COMMUNITY DEVELOPMENT DEPARTMENT
80 Columbia Avenue ♦ Marysville, WA 98270 ♦ (360) 363-8100

August 19, 2022

Re: Soper Hill Station – *Technical Review 1*
PA22030

A PORTION OF THE SE 1/4, SW 1/4, SEC 1, TWN 29 N, RGE 5 E, W.M. CITY OF MARYSVILLE, SNOHOMISH COUNTY, WASHINGTON

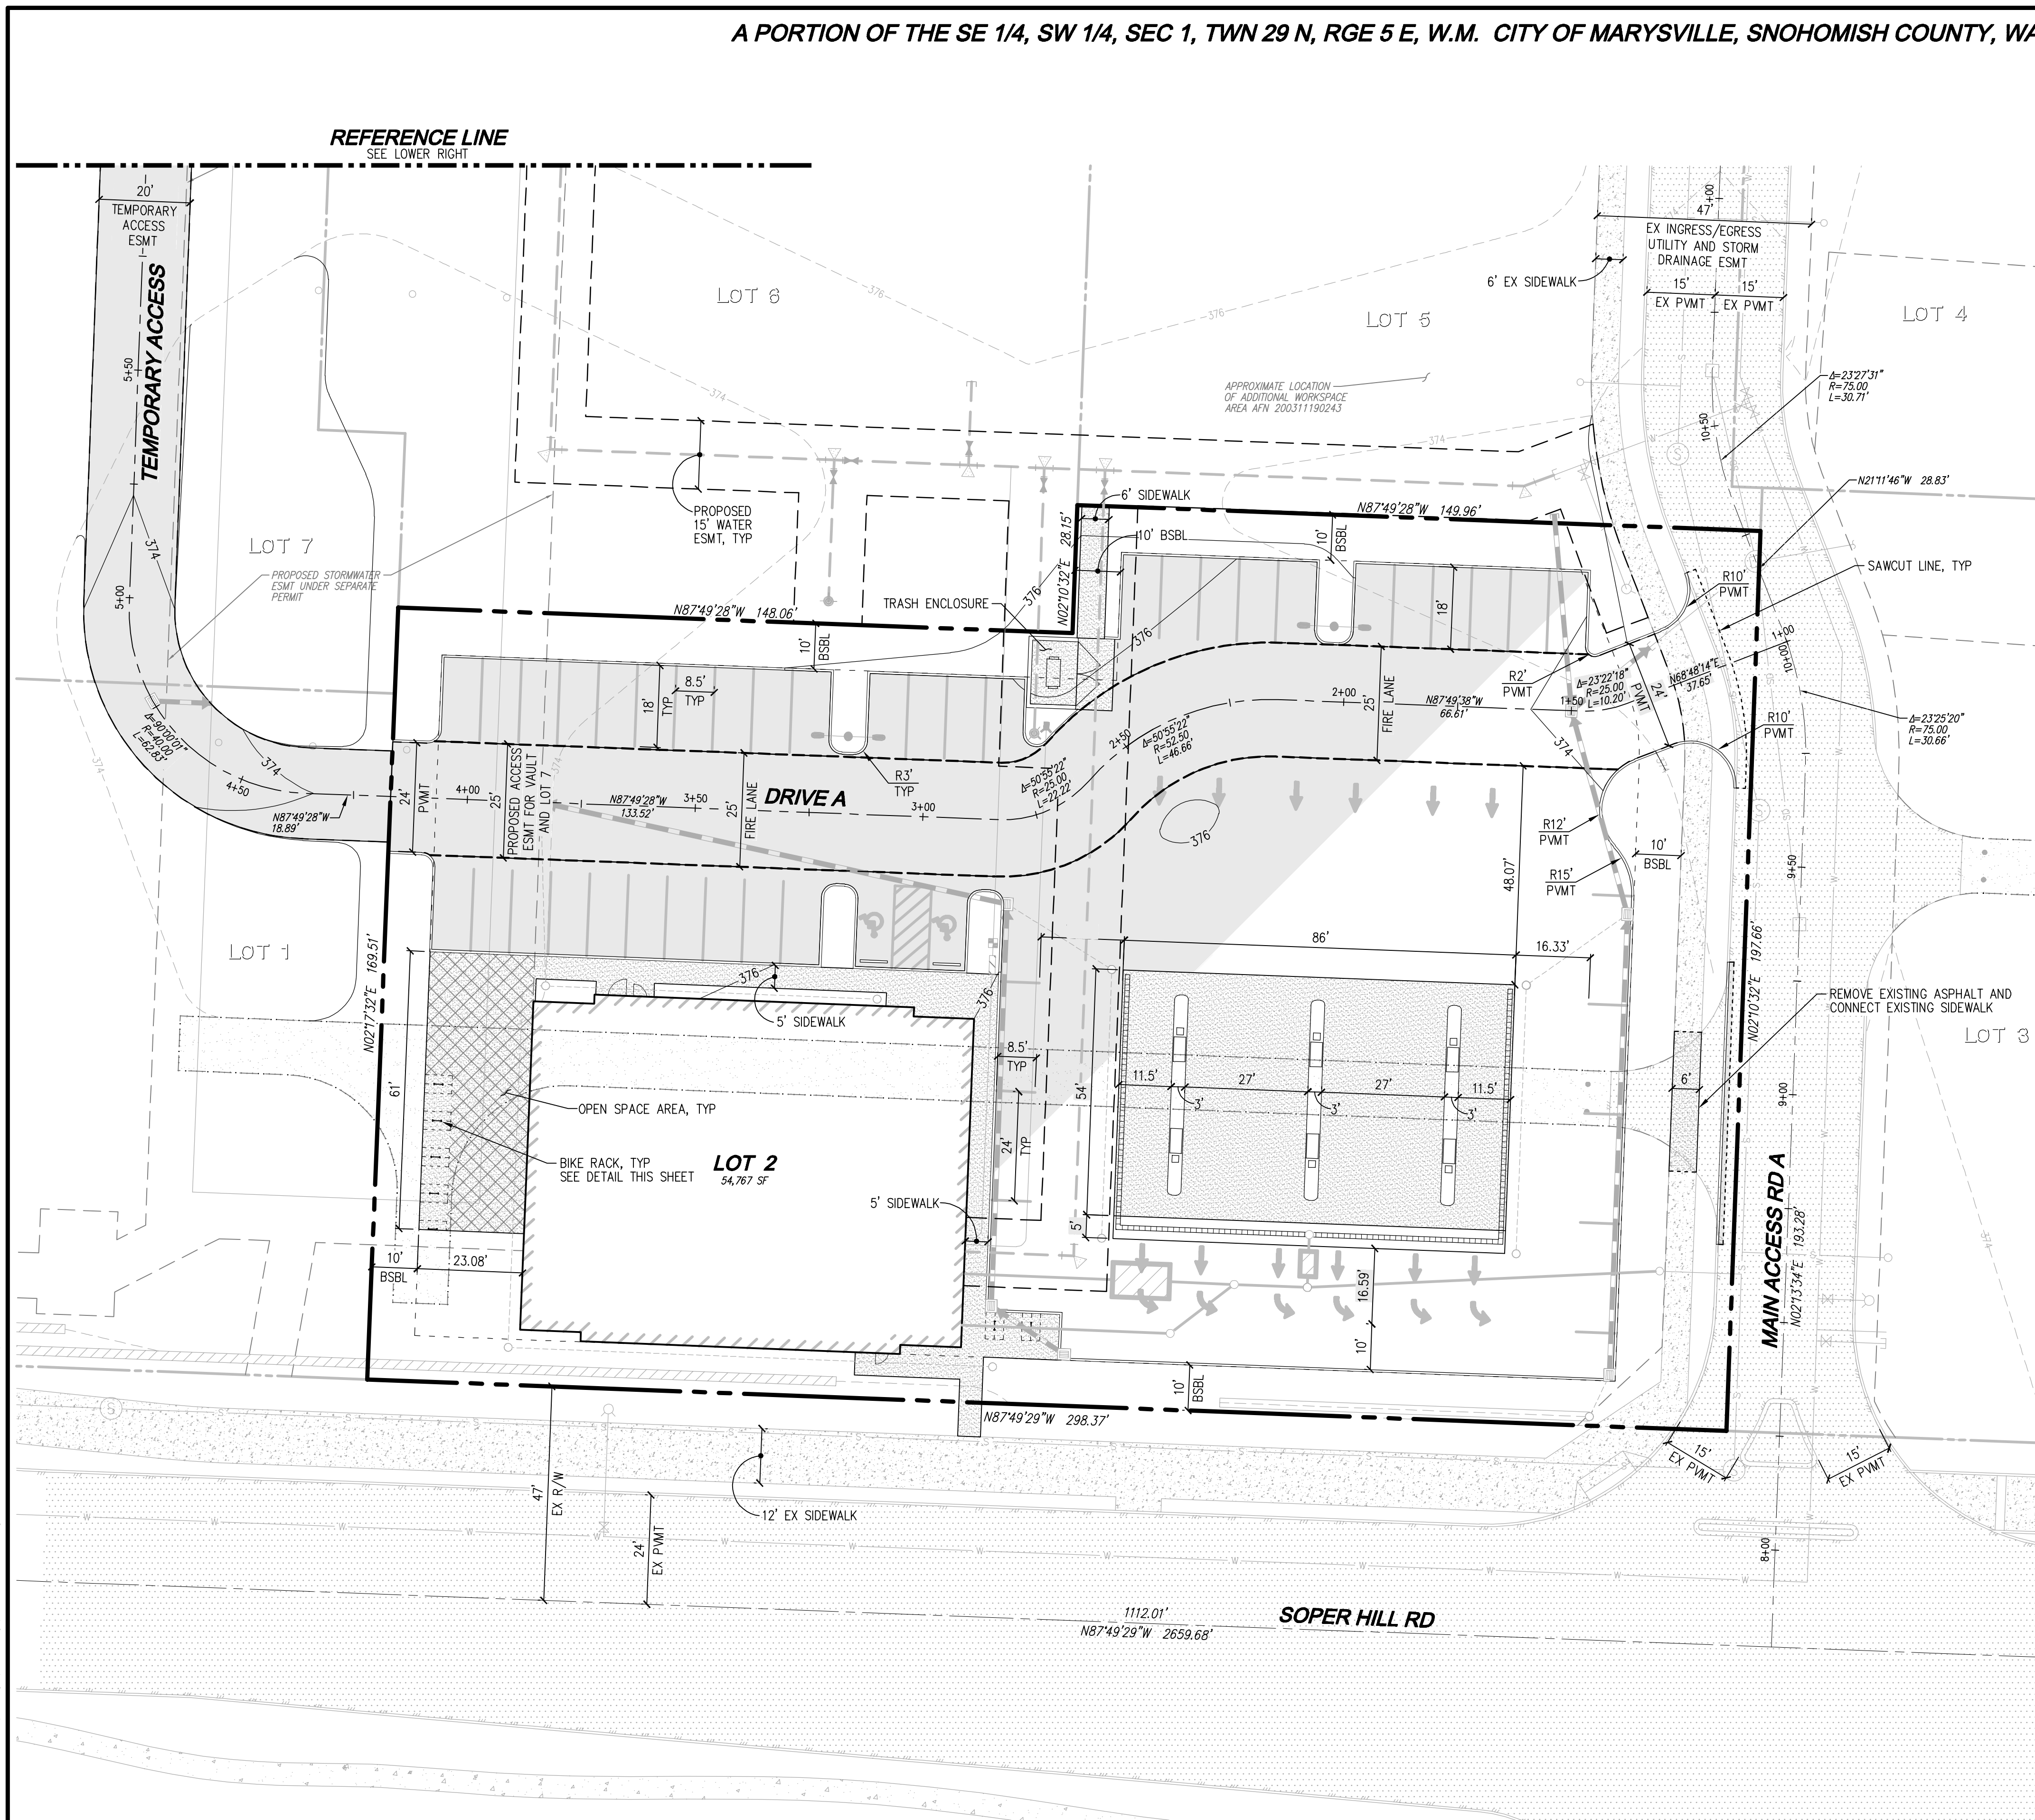
4. Amend Sheet SP-02, as follows:
 - a. Provide impervious surface calculations;
 - b. Provide an auto-turn exhibit with the formal land use application to ensure adequate circulation for both patrons and fueling trucks. Additionally, the applicant shall be required to demonstrate how a fueling truck can safely navigate through the White Barn Center;

- c. Add a minimum 5’ pedestrian pathway from the proposed open space area to Lot 1;
 - d. Provide a pedestrian connection from Lot 2 across the Main Access Drive to Lot 3. Consider potential development of Lots 3 & 4 for location of pedestrian connection;

- e. Amend the parking calculations to include building SF and math for calculating the required number of spaces, similar to the project narrative;
 - f. It appears that some of the proposed parking stalls measure 8’ in width. 8.5’ minimum required;

- g. B.4.1.a. requires a side and rear setback of 15’. It appears the building is only setback 10’ along the south property line
 - h. F.1.1 requires a 30’ landscaping setback from Soper Hill Road and a 20’ setback is required from Road A when a parking areas and drive aisles are located

adjacent to these roadways. The *Director* may approve and condition reduced planter widths provided the design meets the intent of the standards and guidelines. For example, reduced widths may be allowed provided the landscaped area is supplemented with architectural features that help to define the street edge and maintain visual continuity along the street. Examples could include a decorative low wall made of stone or masonry that is used in conjunction with landscaping, and/or use of a landscaped trellis or architectural columns. For each method, it is important to maintain visibility at eye level (between 3 and 8 feet above the ground) between the street into the parking lot for safety.

- i. F.2.4.a. requires service elements (i.e. solid waste disposal areas) to be located to minimize the negative visual, noise, odor, and physical impacts of the street environment, adjacent (on and off-site) residents or other uses, and pedestrian areas. The proposed location of the solid waste collection area will need to be relocated so that it is not visible upon entry into the site.

- j. A minimum 5' L4 landscape buffer is required at the end of the row of parking on the northeast portion of the parking area.
5. The following comments are related to required building design:

# EXTERIOR MATERIAL BOARD - WHITE BARN LOT 2

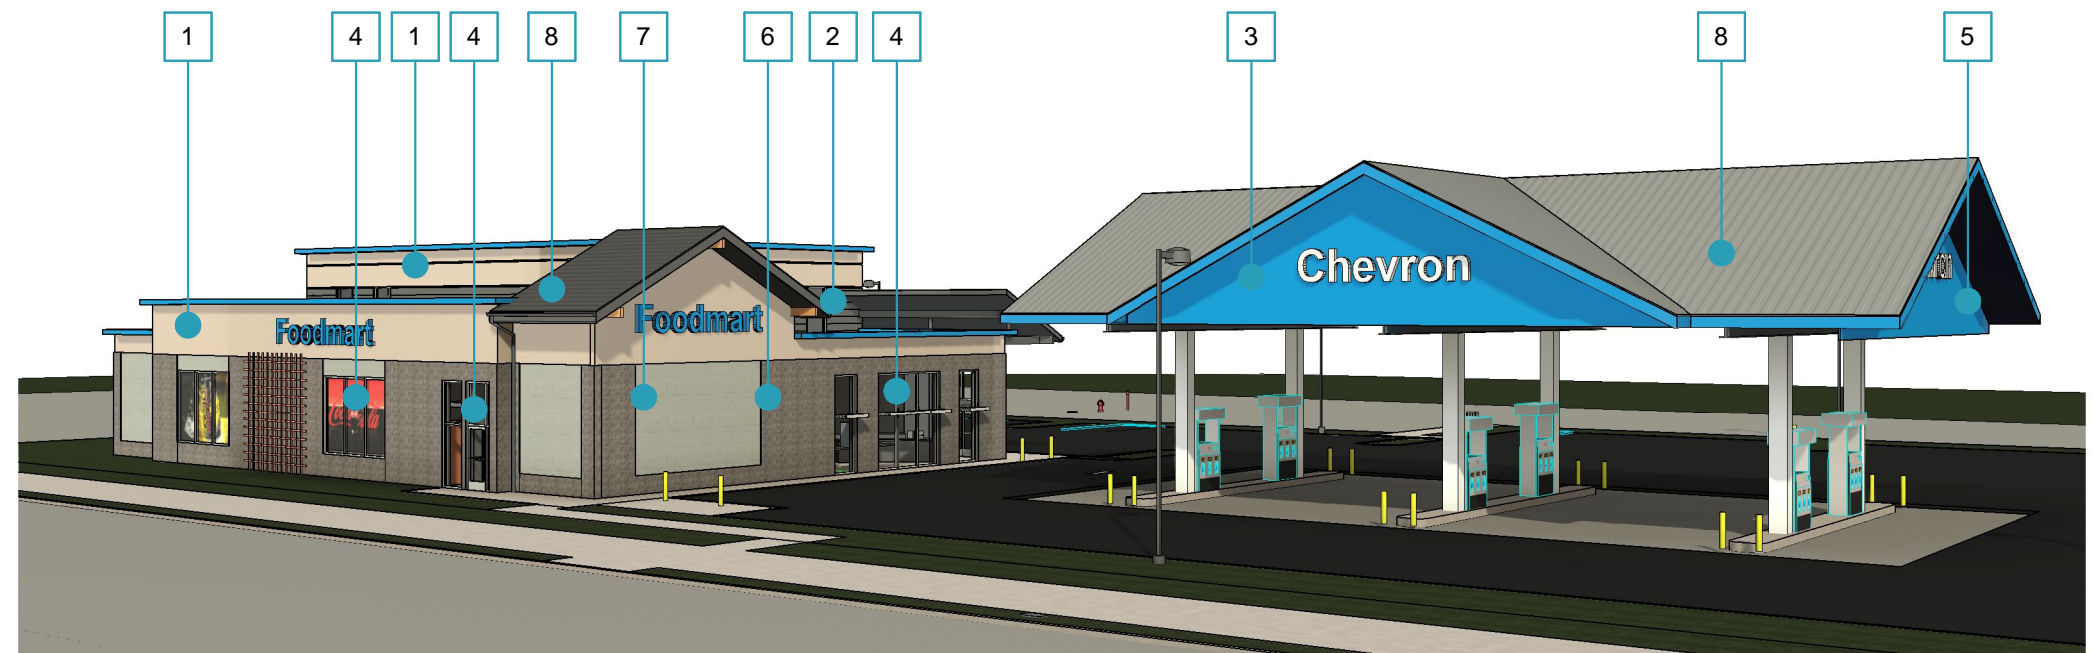
- a. B.1.2.b. requires the ground floor façade between 2 and 8 feet above the ground shall contain a minimum of 75% transparent window area. The north façade does not comply with this requirement.

- b. B.3.2.b. provide pedestrian oriented building façade features on the west elevation facing the open space. Additionally, pursuant to B.3.2.c. blank walls are prohibited adjacent to the open space.

- c. All elevations shall be amended to comply with the blank wall treatment standards outlined in E.3.4. Changing of the CMU wall color does not meet the blank wall standards.

- d. Pursuant to E.4.5 the proposed stucco finish must be trimmed in wood or masonry and should be sheltered from extreme weather by roof overhangs or other methods and are limited to more than 30 percent of the façade area. Weather exposed horizontal surfaces must be avoided.

Date: 6/27/22
 Drawn By: K. Chang
 Marysville, WA - White Barn

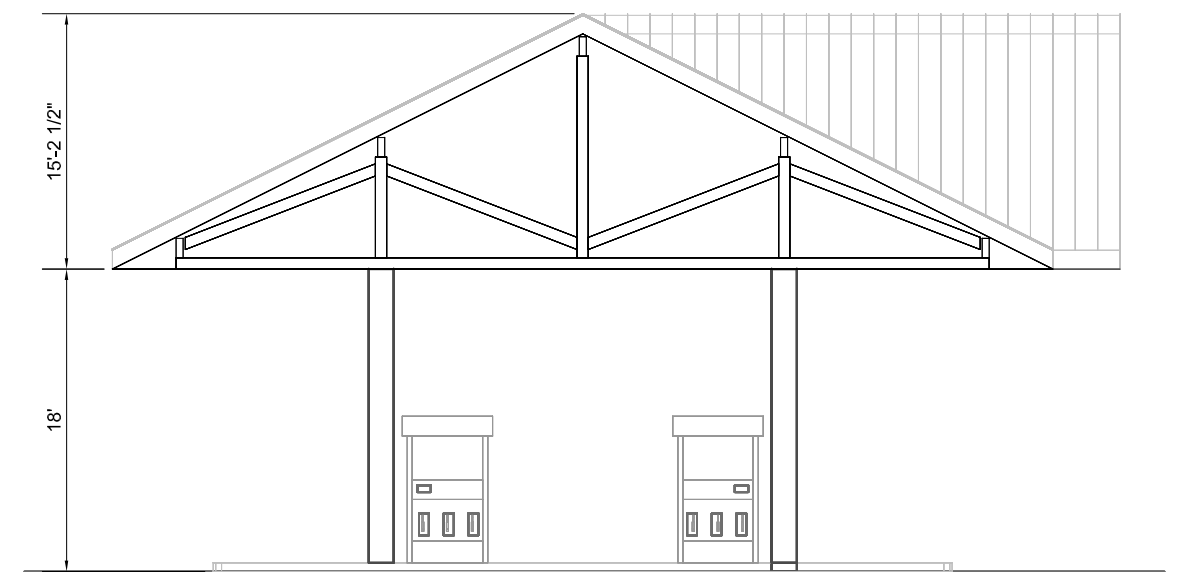
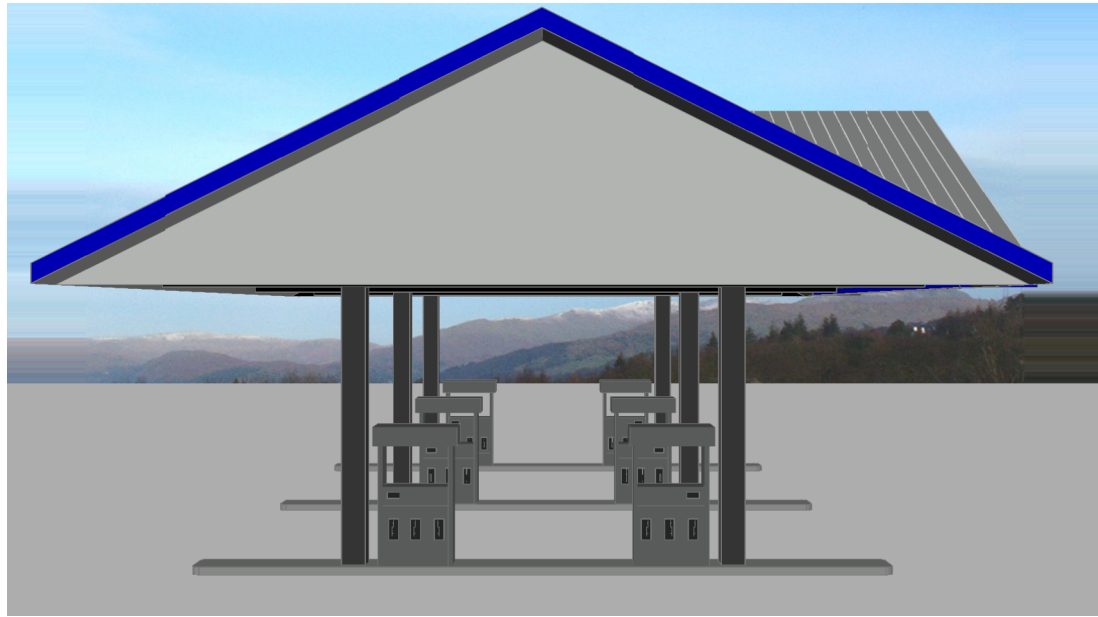
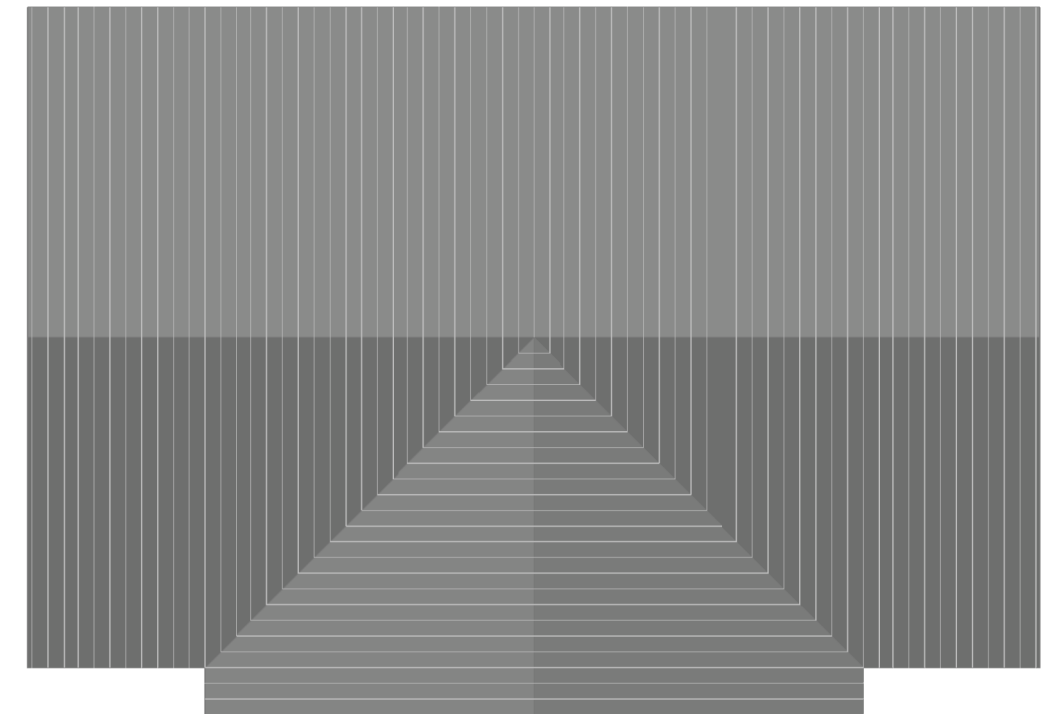
- f. The Canopy Elevations provided do not appear to match the Exterior Material Board elevations provided. Additionally, the Canopy Elevations do not illustrate which elevation is the north, east, south and west. Please amend and the City will provide design review comments on the canopy.
